Administrative Relief Letter of Intent

Kyle Adrian Kenyon
1010 Tari Dr.
Colorado Springs, Colorado Spring

I am writing to the department seeking 20% administrative relief on the front and rear setback requirements for RS-20000 zone lot properties.

A1.3 PLOT PLAN

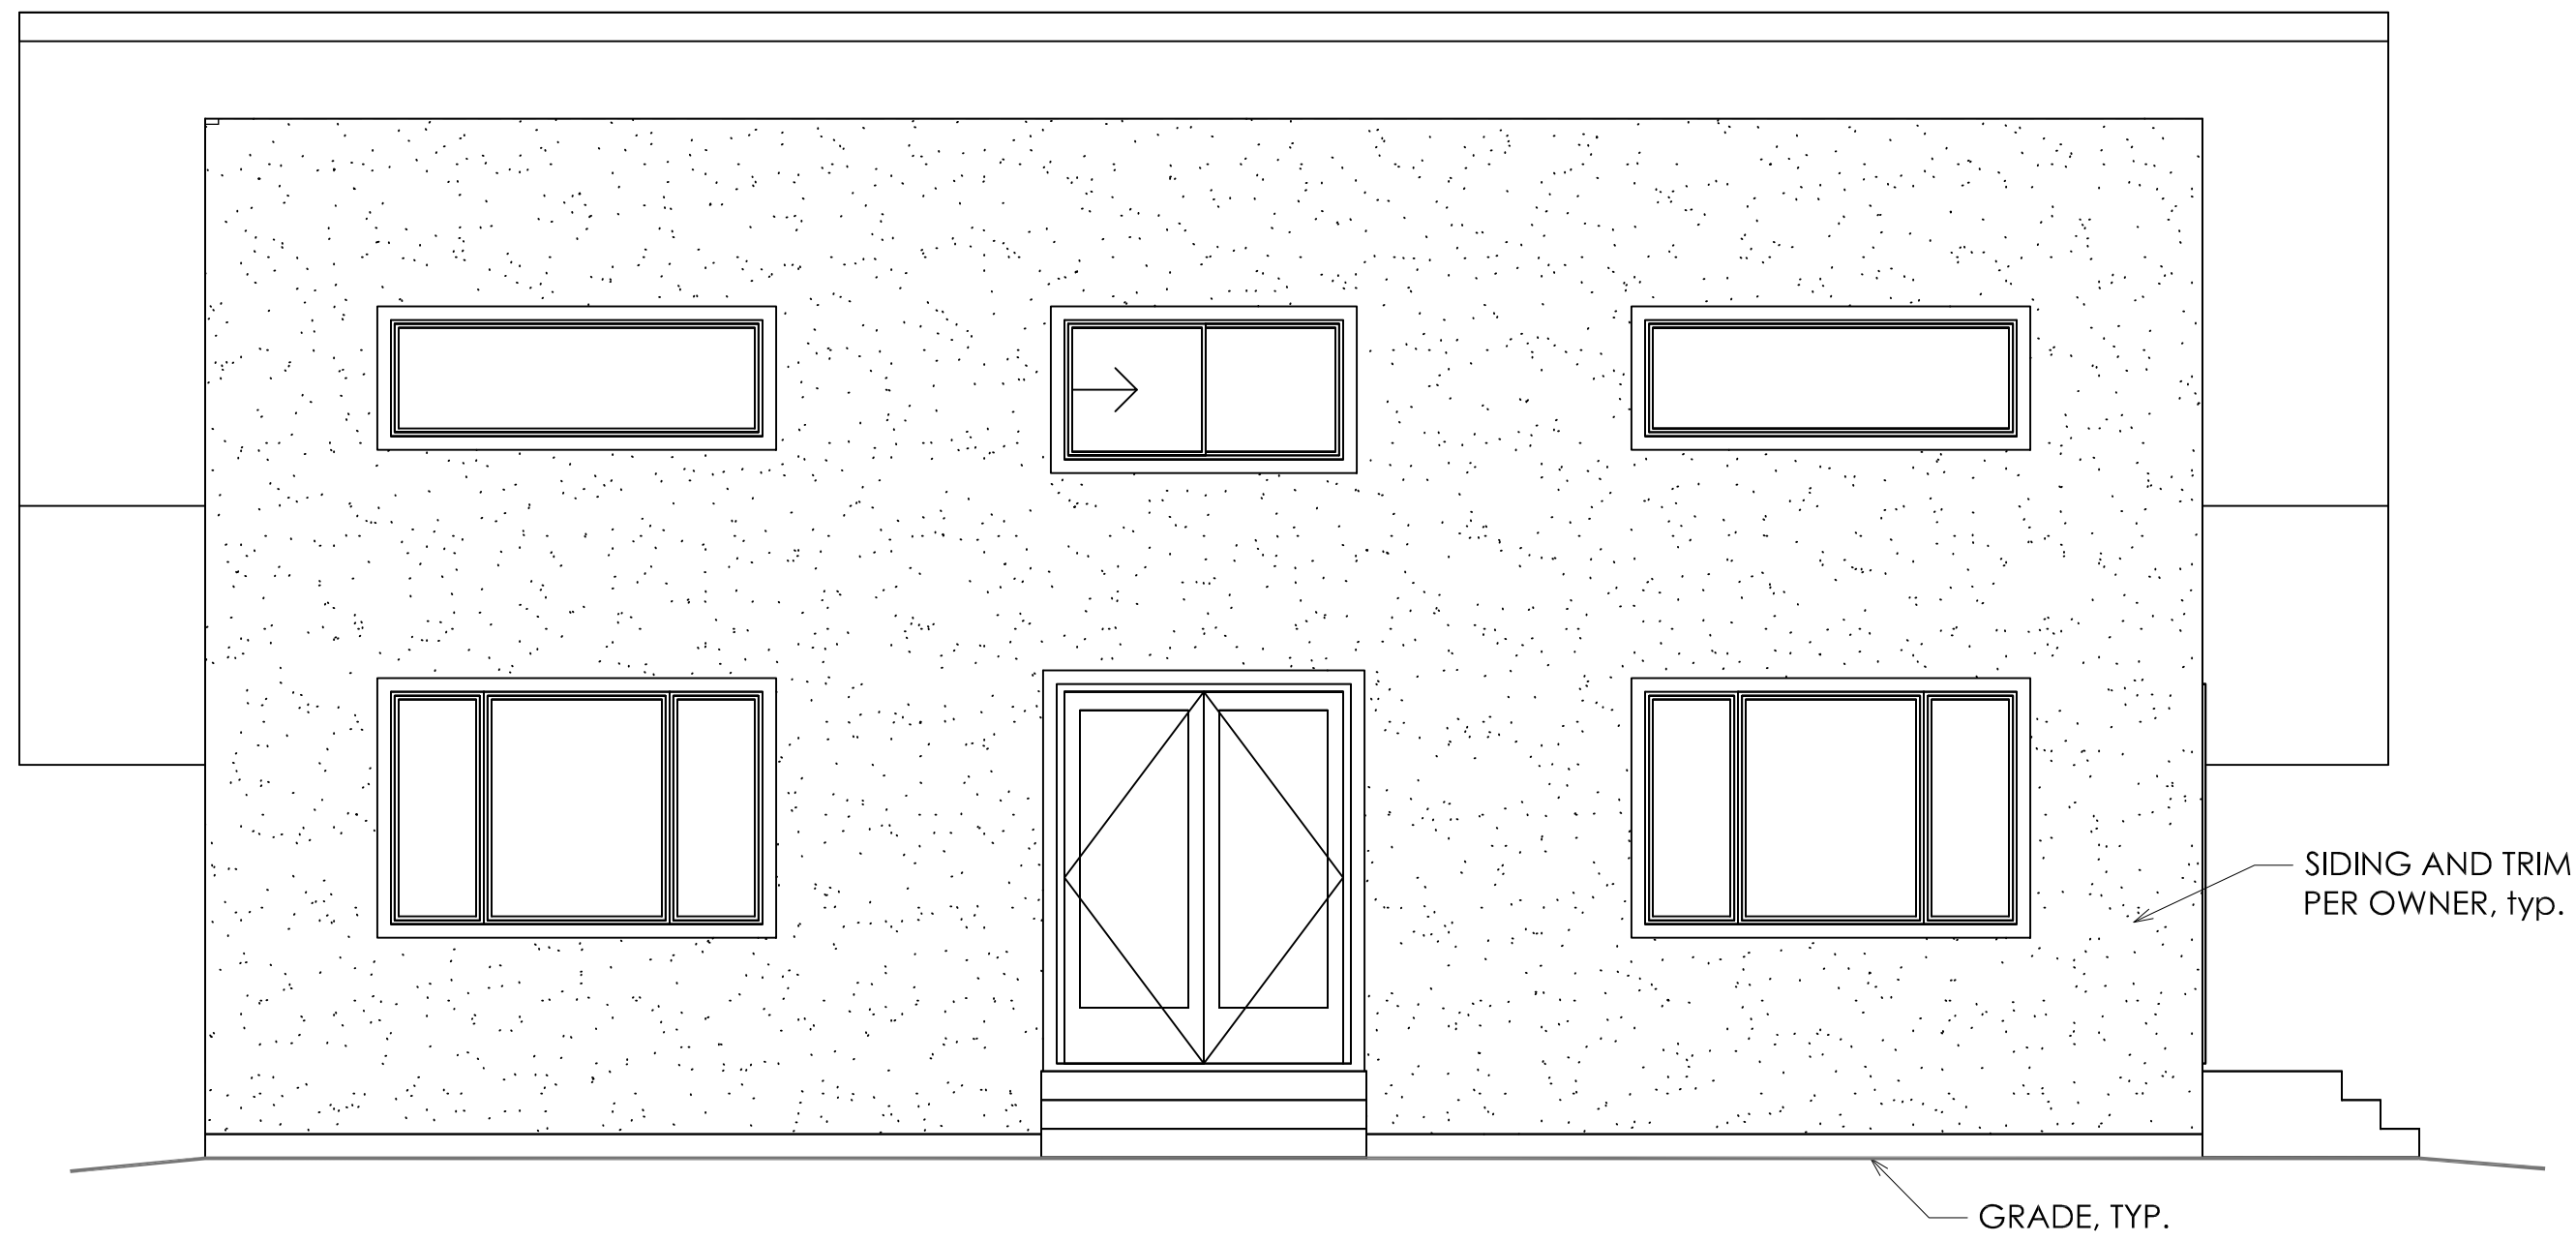
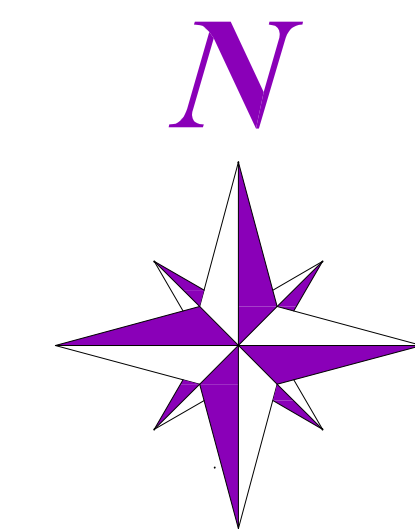
ADU is not allowed in RS-20000. ALQ is allowed but has a maximum square footage of 1500 (Up to 1800 with administrative relief). See email for more details regarding ADU vs. ALQ. If you determine that your standards fit an ALQ rather than an ADU, please change all "ADU" terms to "ALQ" in these submissions.
